CITY OF ALBUQUERQUE

April 20, 2015

RE: **Chick-fil-A**
1600 Gibson Blvd SE
Grading and Drainage Plan
Engineers Stamp Date 3/18/15 (M15D012C)

Sheet
C-3.3

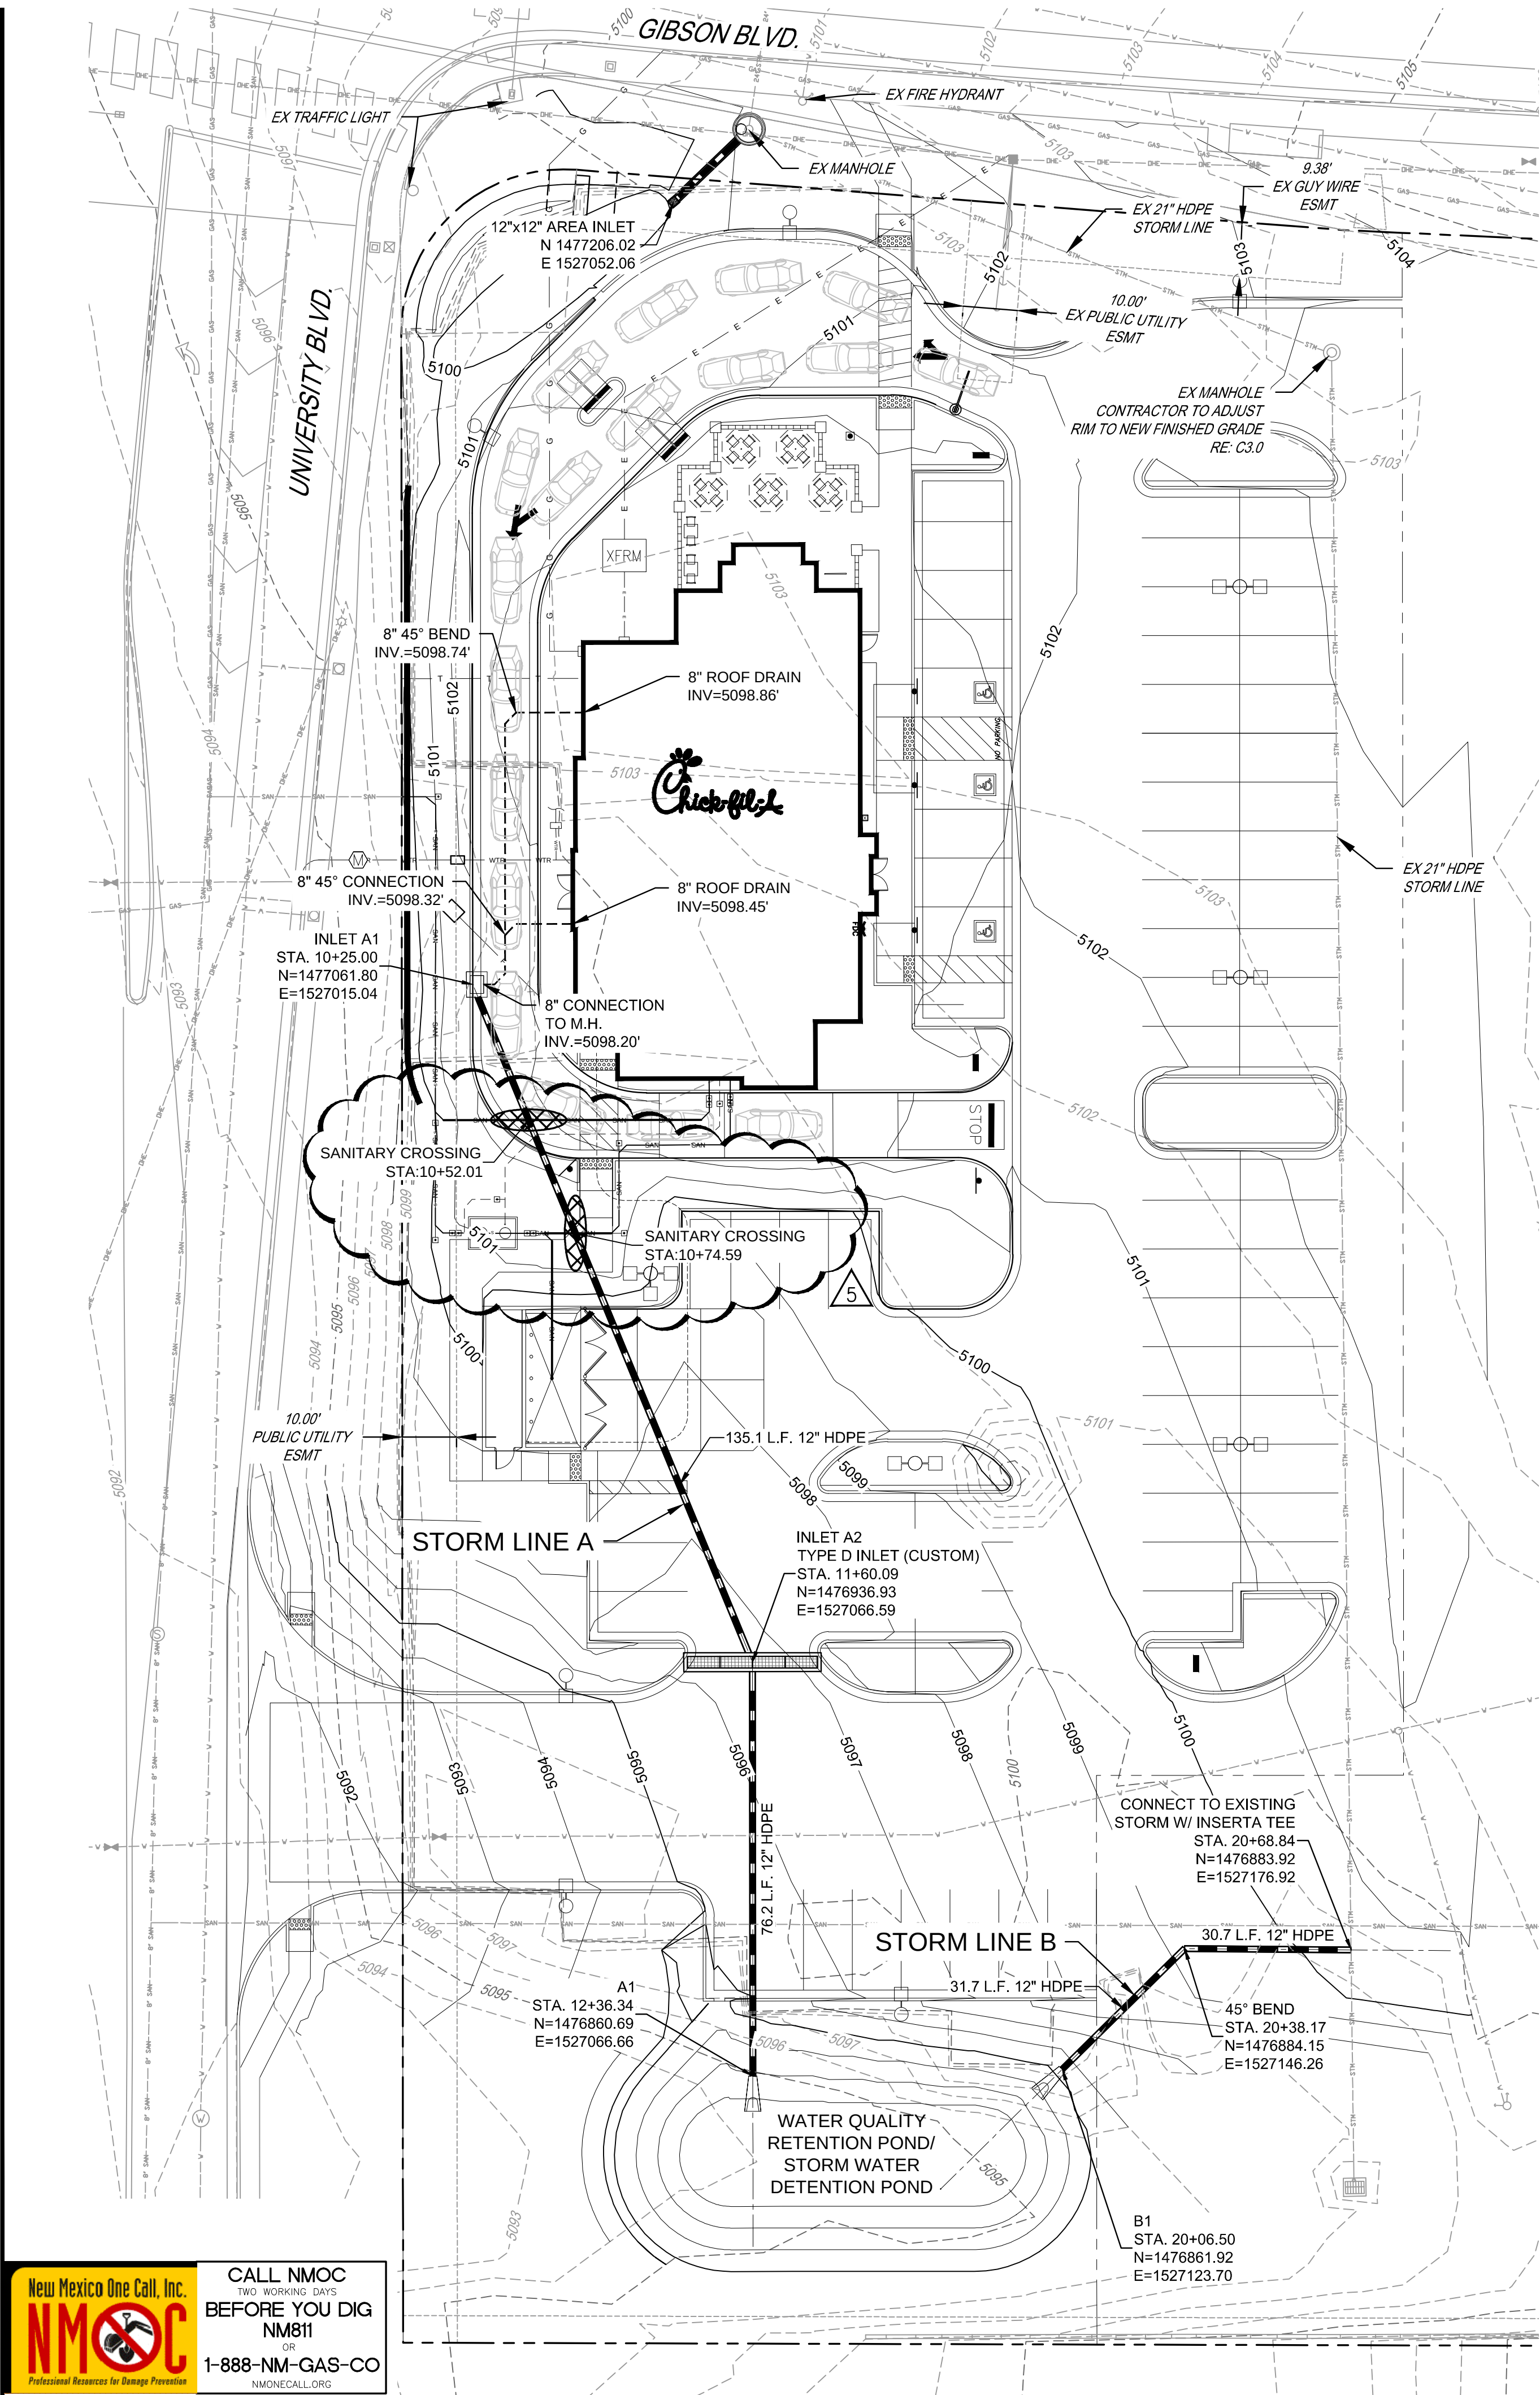
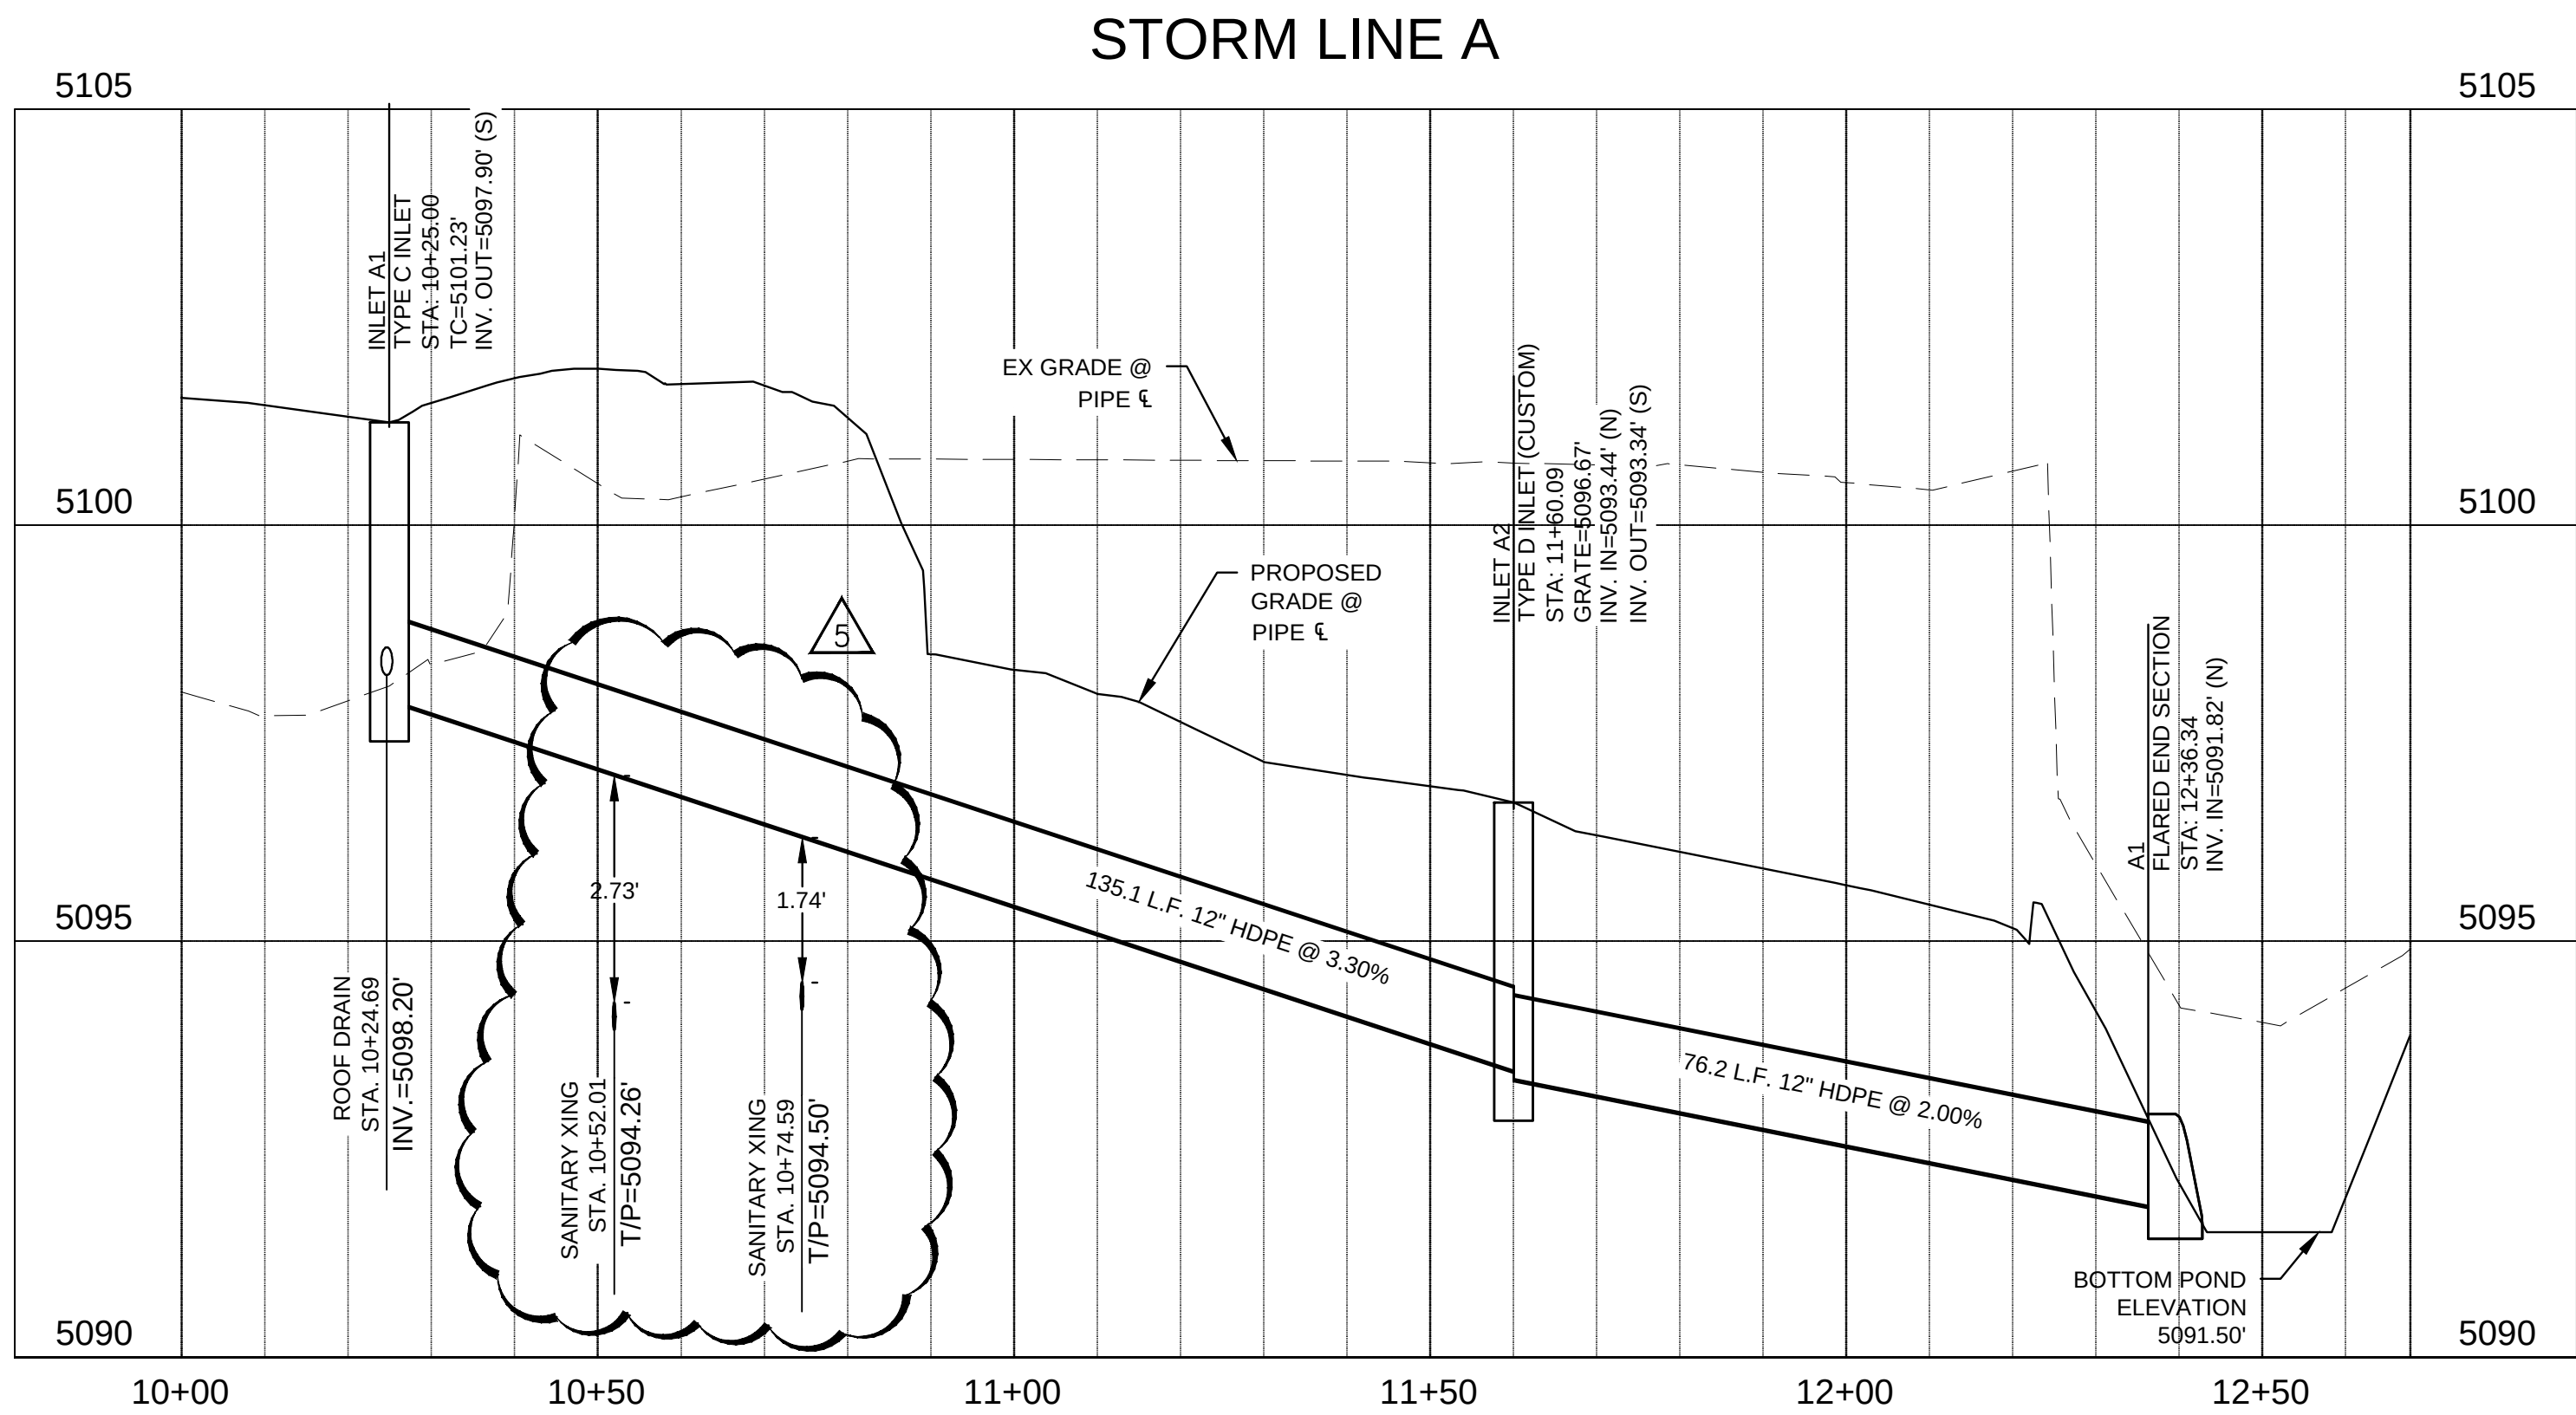
1. Proposed storm drain pipe ties into an existing 21" storm drain.
 - a. Show the existing Storm drain in the profile and section views. Indicate invert elevations of the existing pipe

- d. Provide a connection detail to the 21" storm drain.
2. Verify Pond Bottom Elevation is 92.00 (Sht C3.0). It appears that it needs to be lowered since the invert is at 91.43(Sht C3.3).
